Our Ref: 20337

**RE:     MARIST CATHOLIC COLLEGE NORTH SHORE  
        RESPONSE TO DPIE REQUIREMENTS DATED 20 DECEMBER 2021**

The attachment responds to each of the traffic and parking related matters one by one in **Attachment 1**.

Title
GA PLAN - BASEMENT ZONE 1

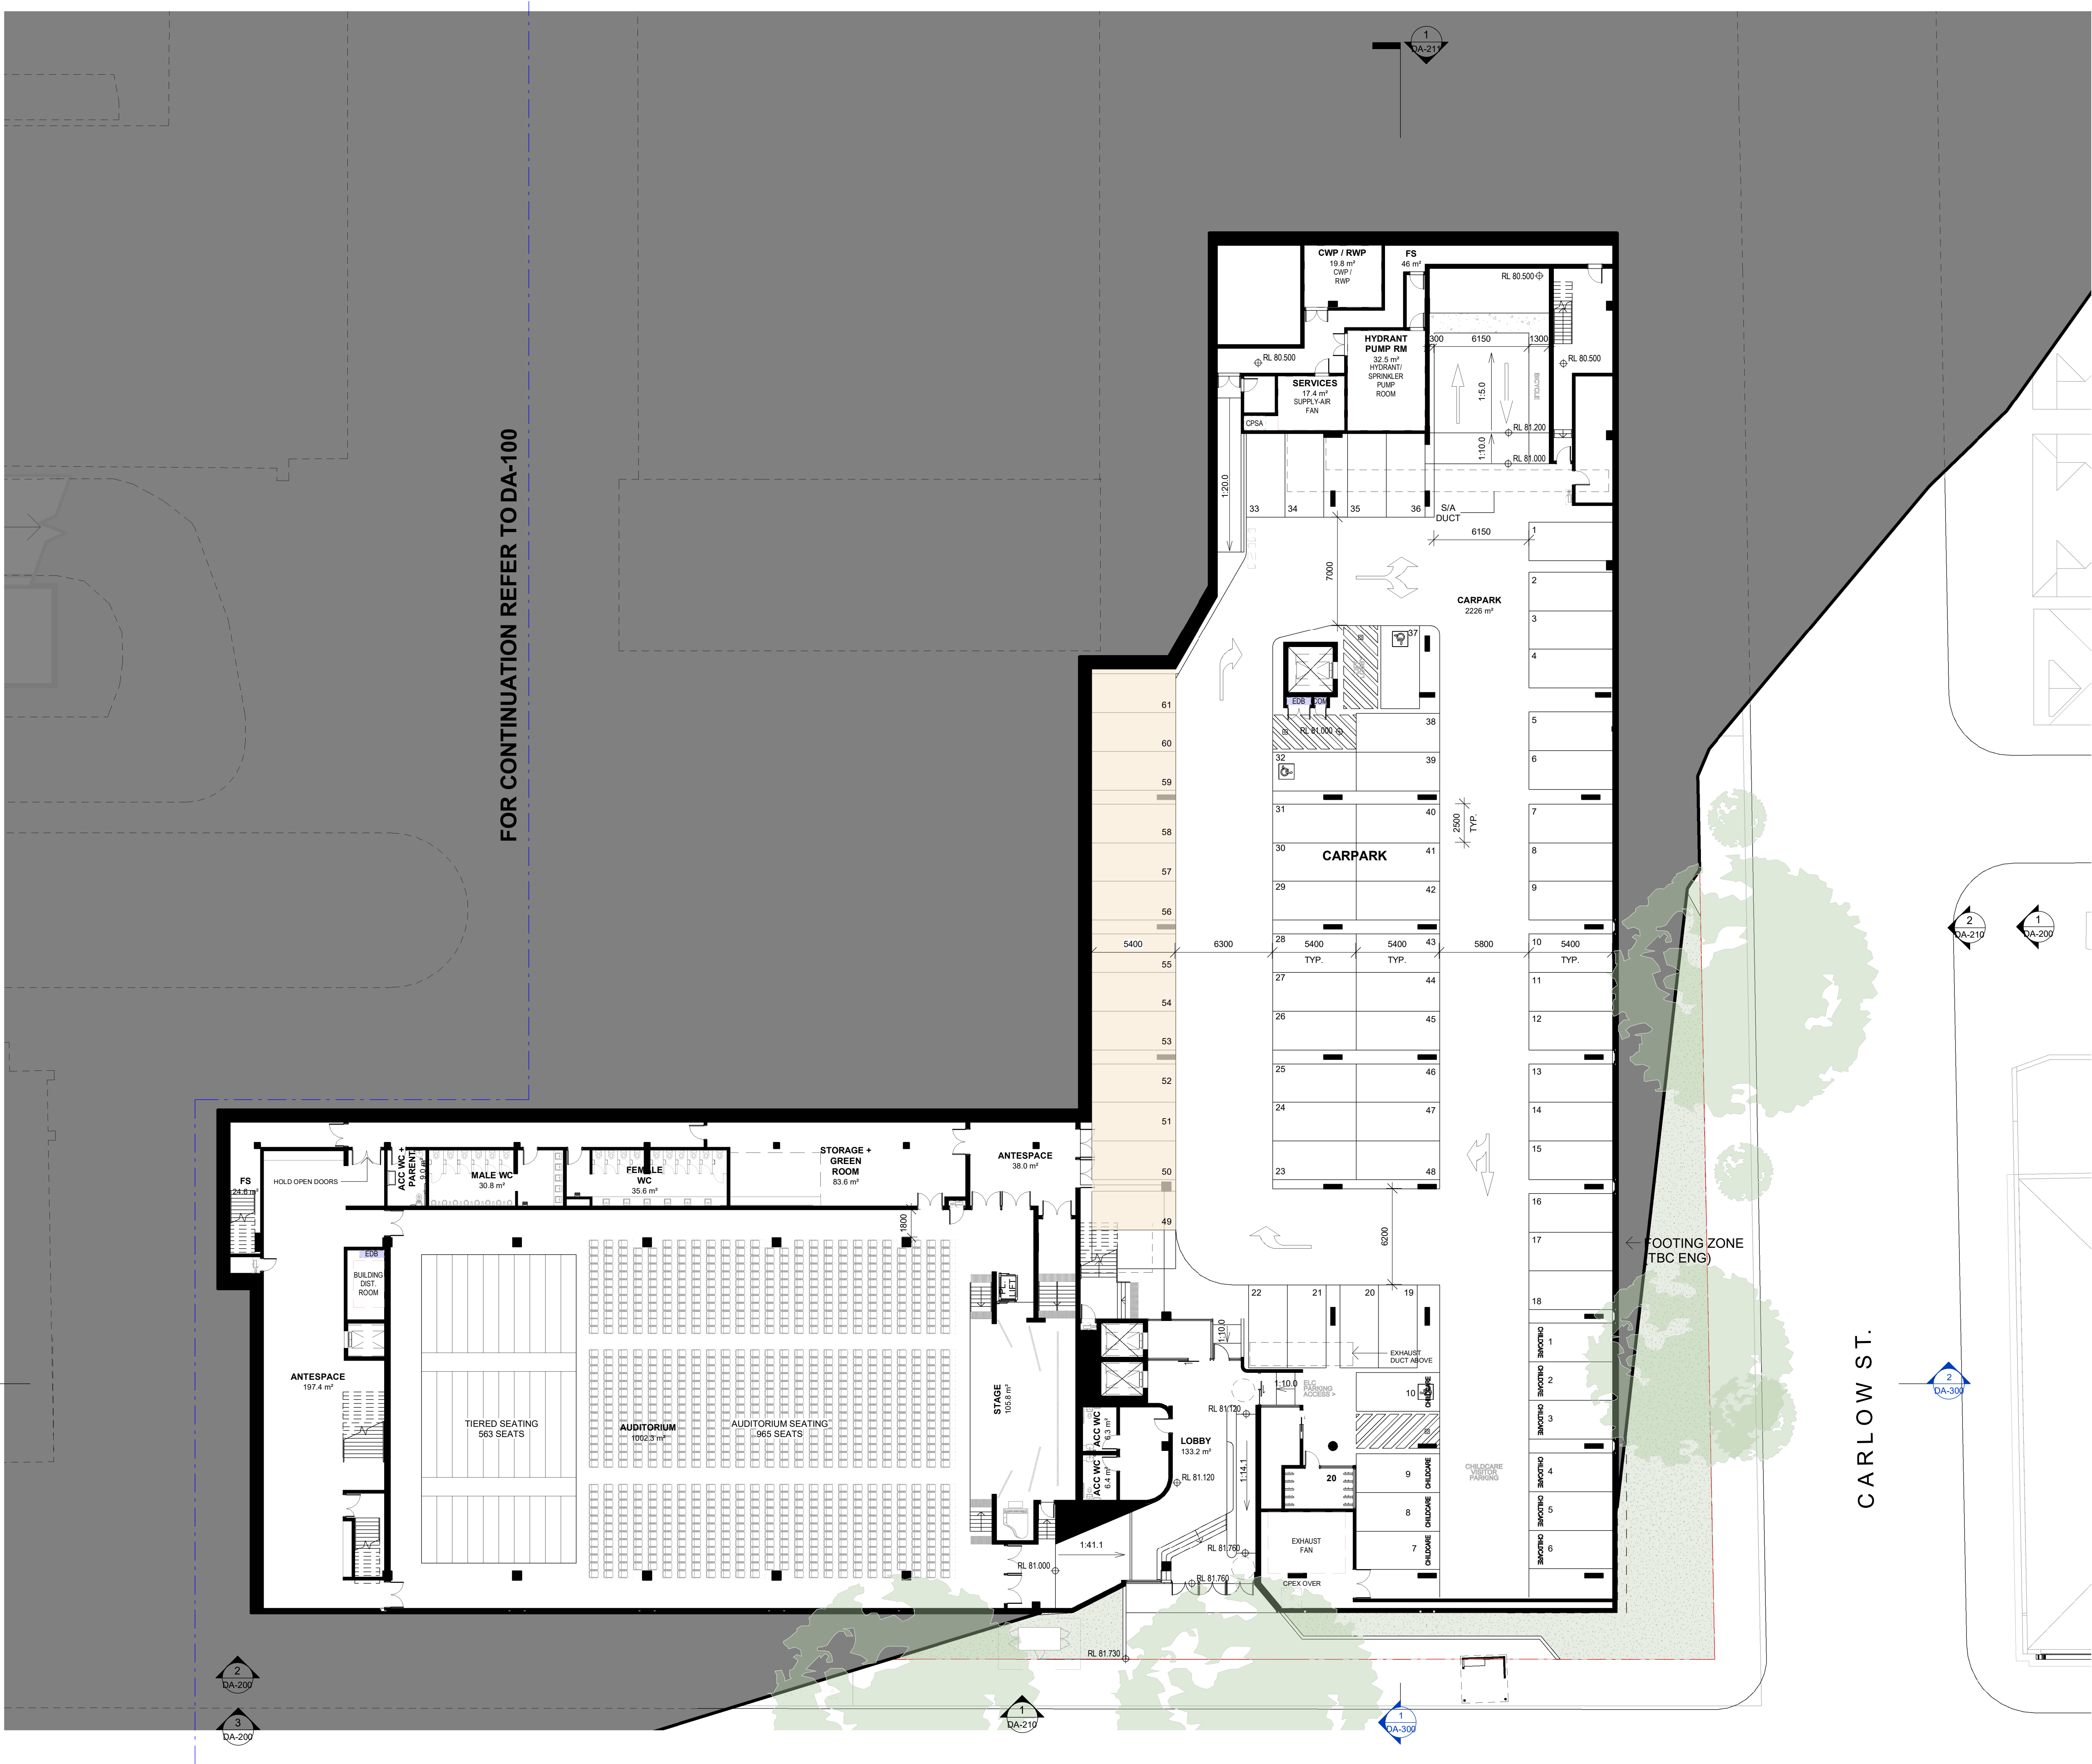
4.3	<p>Clarification of the proposed allocation of parking spaces, in particular:</p> <ul style="list-style-type: none"> <li>at the basement level of the Carlow Street building, noting the RTS states there are 50 staff parking, 9 childcare, 12 PUDO. However, the architectural drawings indicate 48 staff parking, 10 childcare and 13 Years 2-12 PUDO.</li> <li>the use and allocation of the Ron Dyer spaces.</li> <li>the use of the Carlow Street building PUDO and childcare spaces outside of PUDO times.</li> </ul>	The parking provision calculation in the TIA has been modified to be consistent with the architectural plans.	See Section 5.1.6
